Appeal Decision

Appeal Ref: APP/R4408/W/21/3281156

Land off Royd Moor Road, Thurlstone, Sheffield S36 9RY

- The appeal is made under section 78 of the Town and Country Planning Act 1990 against a refusal to grant planning permission.
 - The appeal is made by Mr and Mrs L Barden against the decision of Barnsley Metropolitan Borough Council.
 - The application Ref 2021/0571, dated 16 April 2021, was refused by notice dated 30 July 2021.
 - The development proposed is described on the application form as 'full application for 1no dwelling following demolition of existing stables and associated structures'.
-

Front Elevation to Royd Moor Road.
as Proposed.

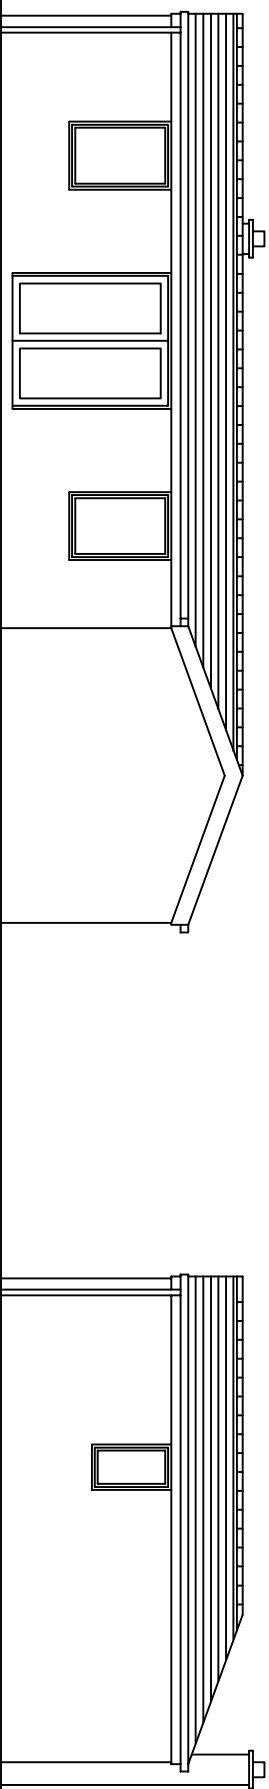
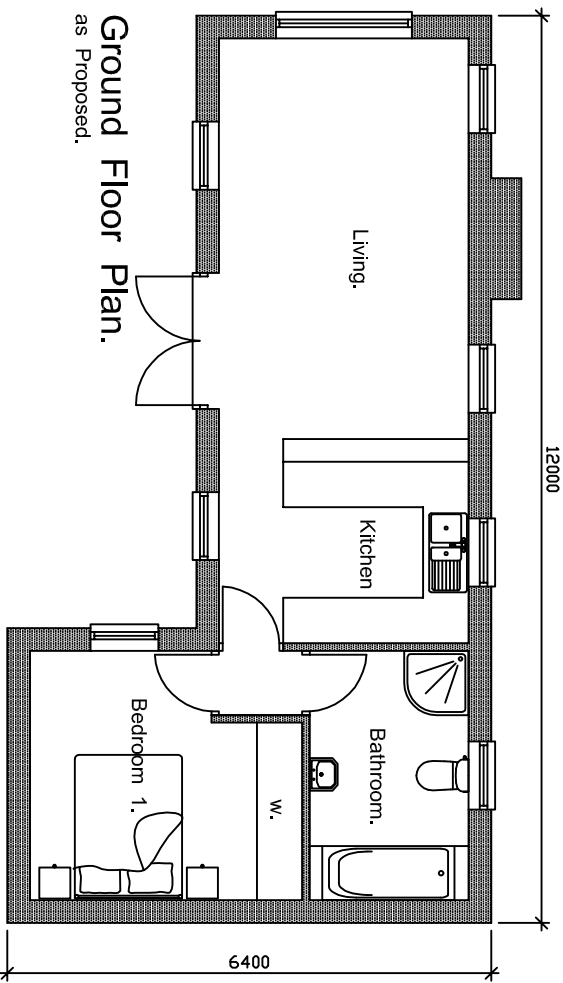
9. Whilst the overall volume of the proposed dwelling would be less, its ridge line would be higher, resulting in a greater overall mass. Furthermore, the design elements for a dwelling, including the use of extensive glazing and the chimney breast, the illumination that would occur, and the domestic paraphernalia and activities that would be associated with its use as a dwelling would have something of an encroaching urbanising effect that would be markedly at odds with the site as it is at present, and with the open and undeveloped rural character of the wider area. The use of timber for the dwelling rather than stone would not adequately mitigate this, nor would boundary planting.
